**KIRKLEES METROPOLITAN COUNCIL
INVESTMENT & REGENERATION SERVICE**

**DELEGATED DECISION TO DETERMINE APPLICATIONS FOR
NON-MATERIAL AMENDMENTS**

Reference No: **2026/NM/92008/W**

Site Address: 65B, Westgate, Almondbury, Huddersfield, HD5 8XF

Proposed front/west facing elevation (1:100)

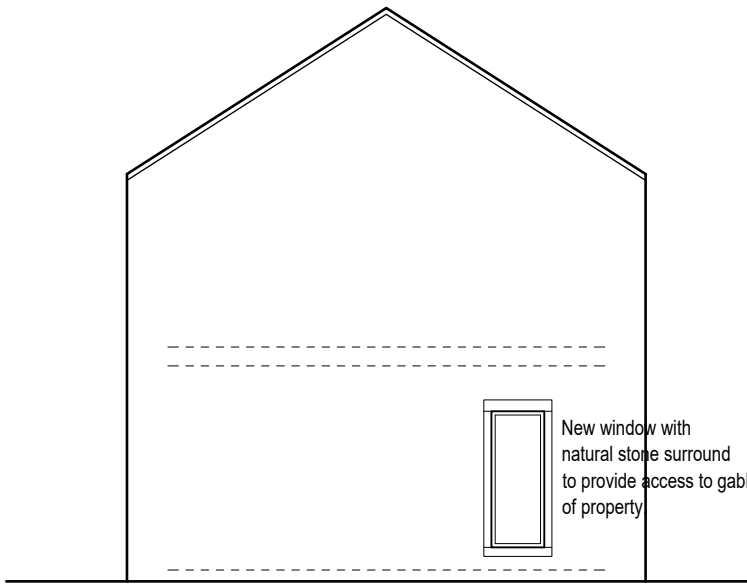
The proposal would see the alteration of the scheme to a minor degree. The alteration to the re-location and removal of the proposed windows would not affect the visual appearance / impact upon the setting to an extent that it is materially different to the originally approved development. Though the applicant is seeking approval to increase the size of the roof light, given the oblique angle this would be sited at, it is not considered to give rise to any

Though the applicant proposes to increase the size of the roof light, the oblique angle this would be sited at it is not considered to give rise to any significant issues.

The amendments sought to omit two rear windows, relocate 1 window and increase the size of the proposed roof light, as shown on drawing number 02F and 02C as received by the Local Planning Authority on 21.07.2026, is considered acceptable as a nonmaterial amendment to the approved scheme under planning reference number 2026/90664.

Proposed side/west facing elevation (1:100)

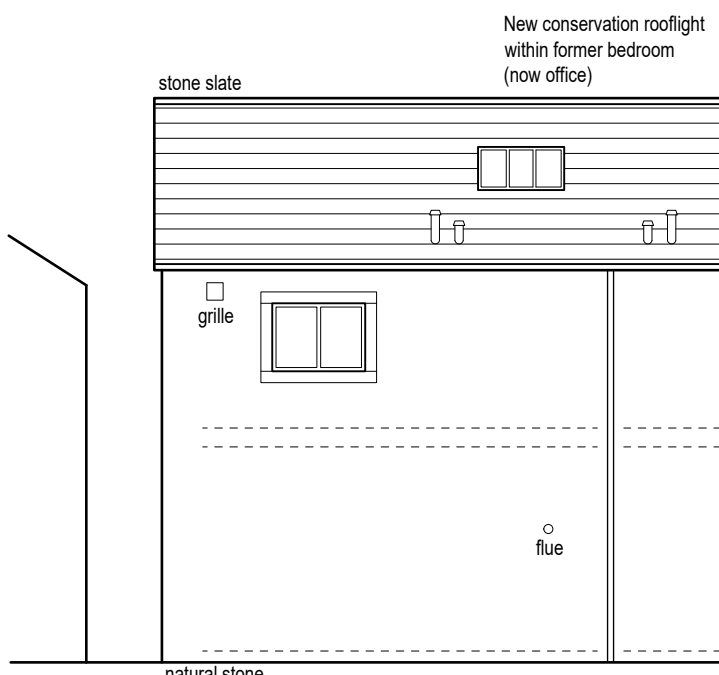
The proposed amendment would relocate the side-facing window further to the right of the dwelling. As outlined in the original case officer's report, the positioning from the side elevation of No.67 and location along an alleyway gave no rise to overlooking or privacy concerns. As such, the proposed amendment would not present a disadvantage and would comply with the policies set out in the original case officer report.

Proposed rear/east facing elevation (1:100)

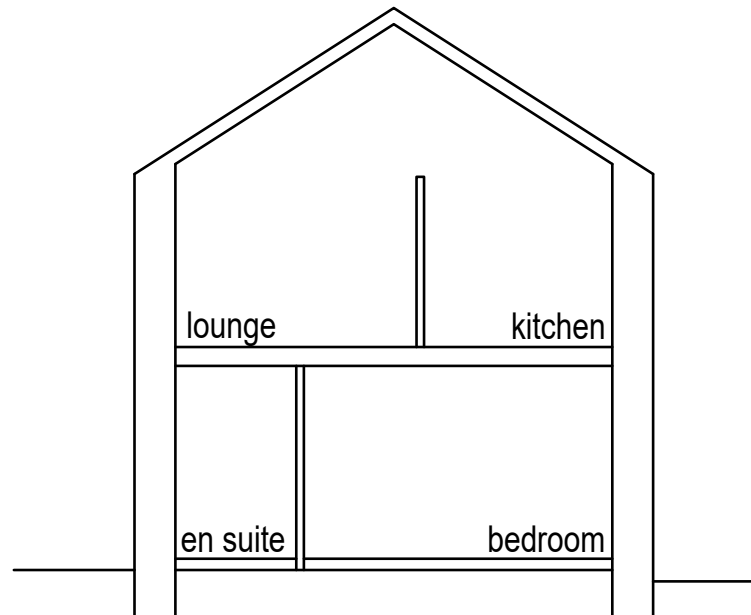
The proposed omission of two windows to the rear of the property, due to complications with access to the rear elevation, would not have a significant impact on residential amenity and in this case, the proposals of the approved development are concluded to remain satisfactorily adhered to by the revised scheme, the subject of this application.
